My Ref: 28Kingsway-AW/155/17/PL-1

10th July 2017

Ref: **OBJECTION to Planning Application: AW/155/17/PL**
Brus Lodge, 28 Kingsway, Craigweil

Tree Retention and Protection Plan

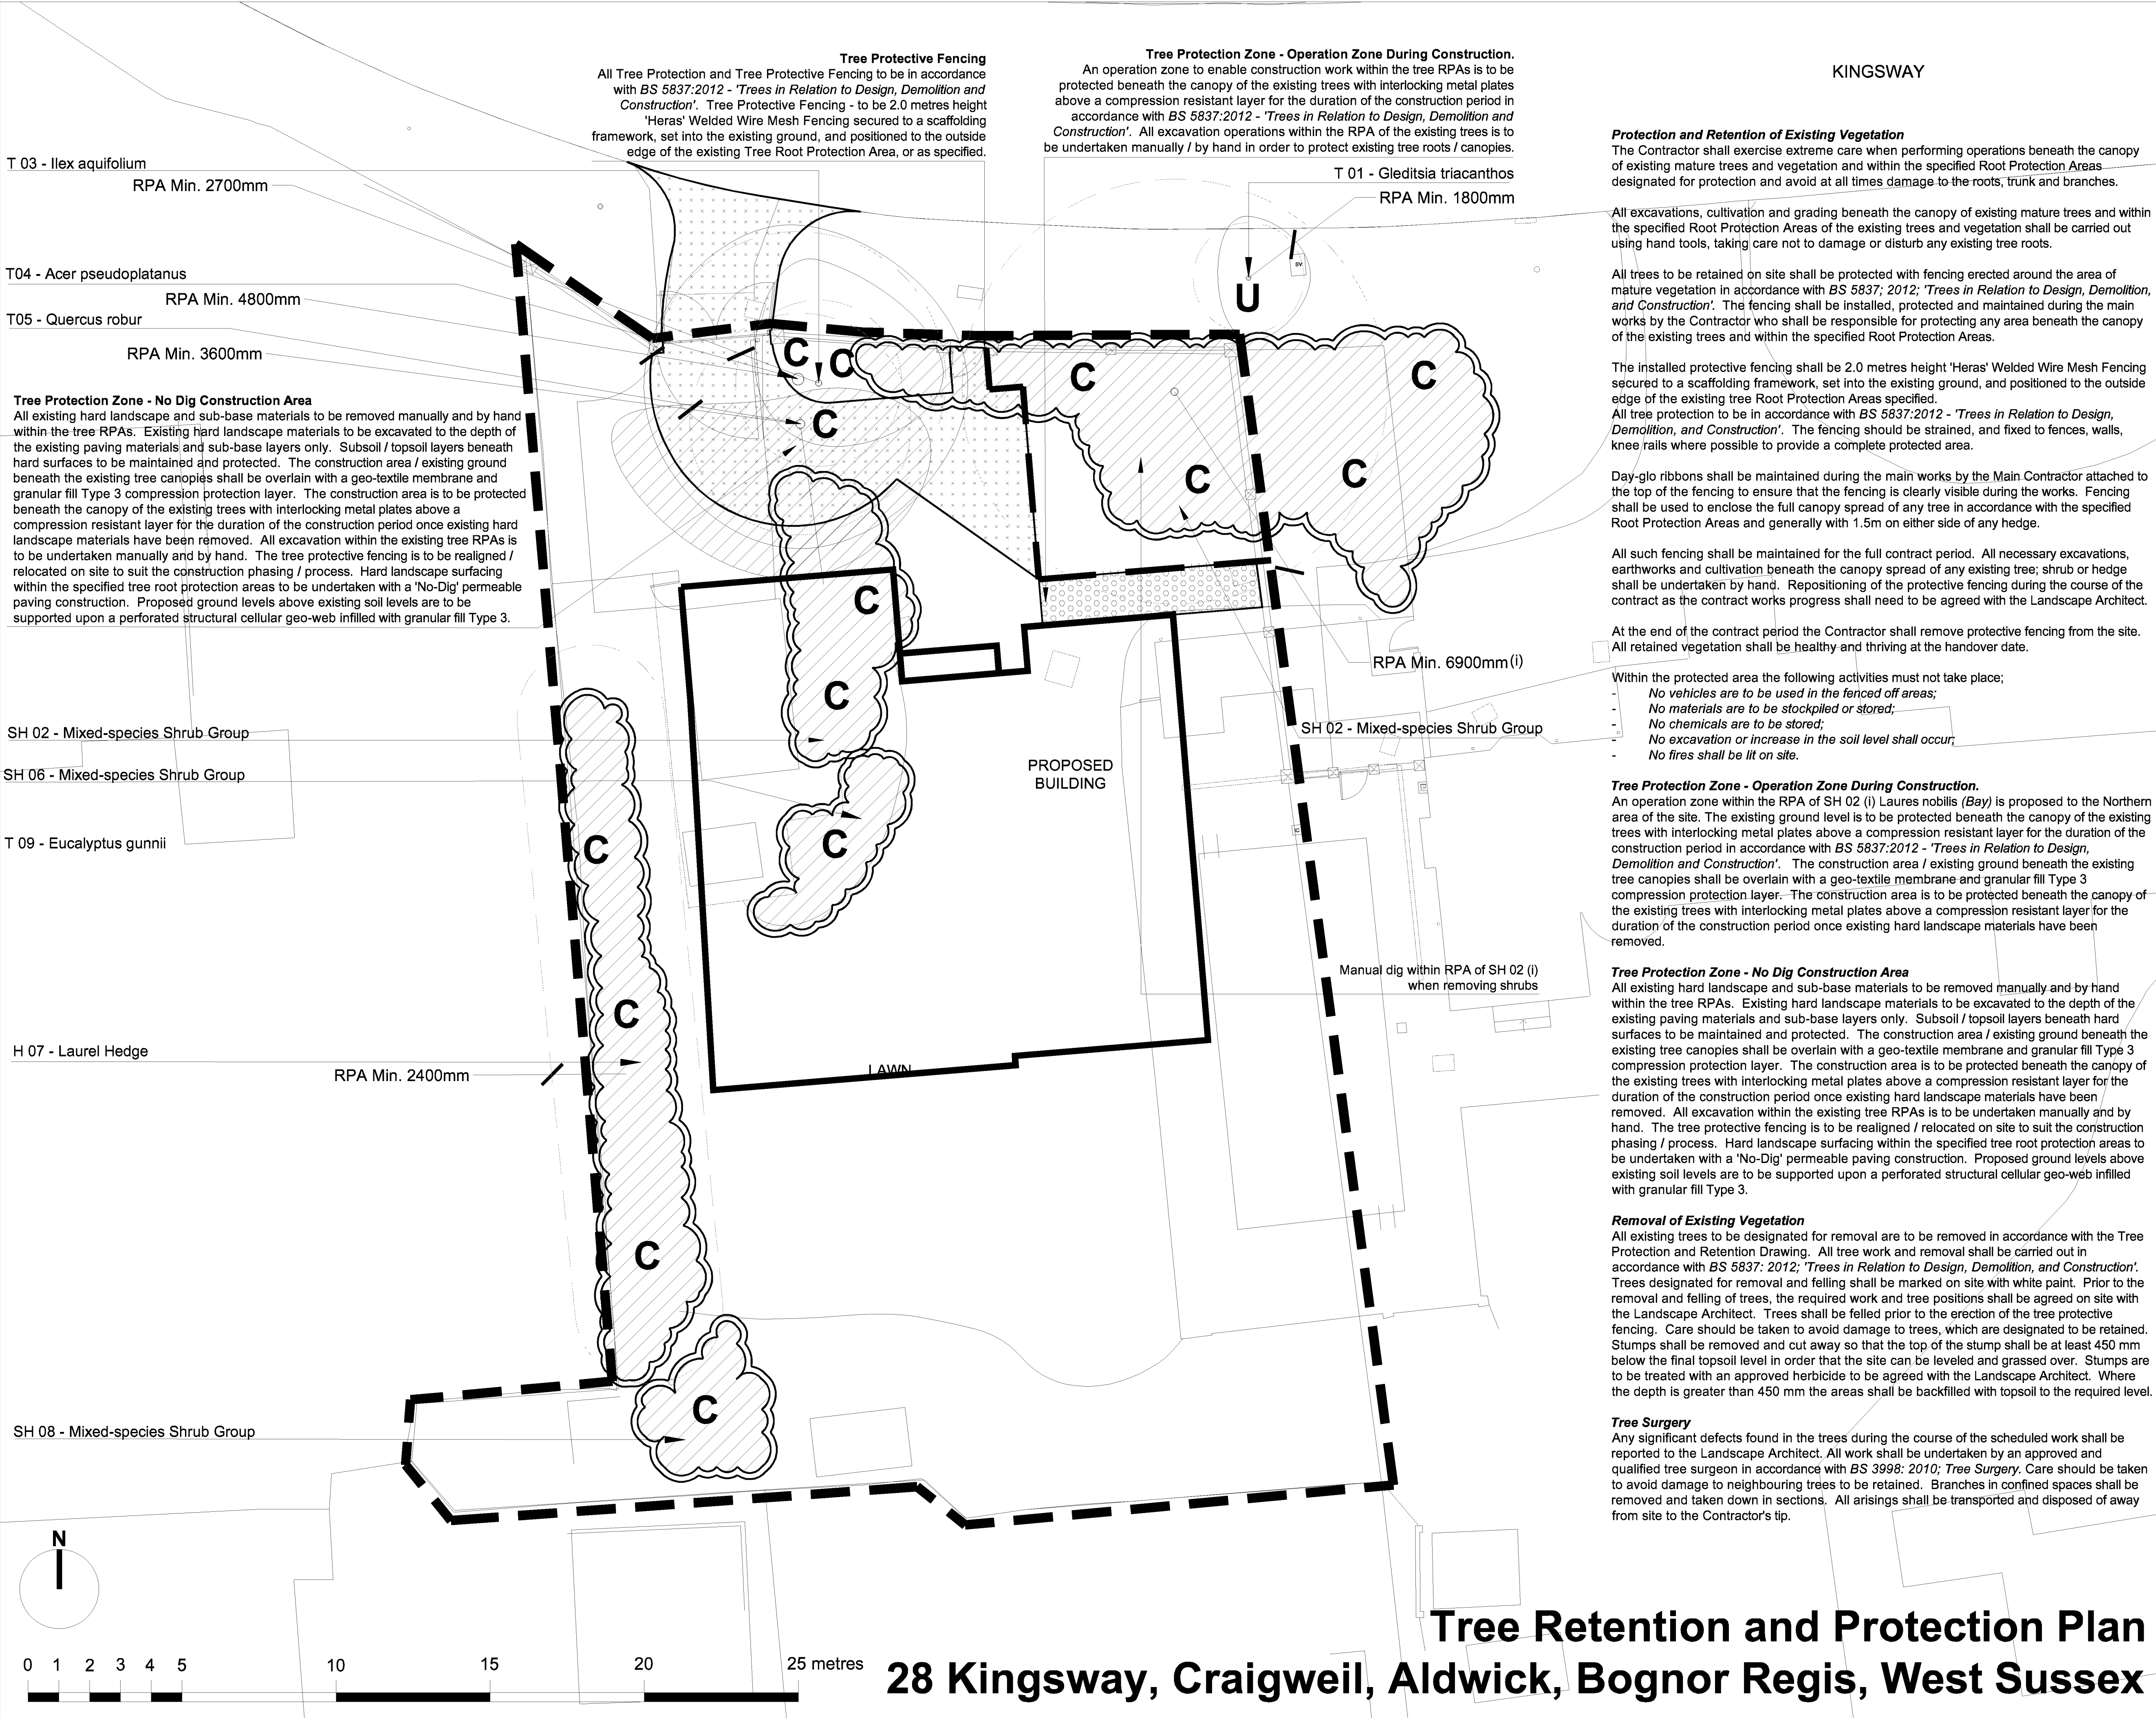
6. **Mr.Seaman, in his email of 5th July to the Case Officer promotes his documents as a deep analysis of tree/vegetation retention, yet SH 02, Page 2 of the Tree Schedule – it says under ‘Status’ – “Retain Bay Tree – Remove all other Shrubs beneath.” That could not be clearer, all but the present TPO'd tree/s will be removed from the Northern boundary to the property. This is not in the interests of the CHCA or ASC, it positively harms the character and appearance of the areas and makes absolutely NO contribution to their retention or enhancement.**
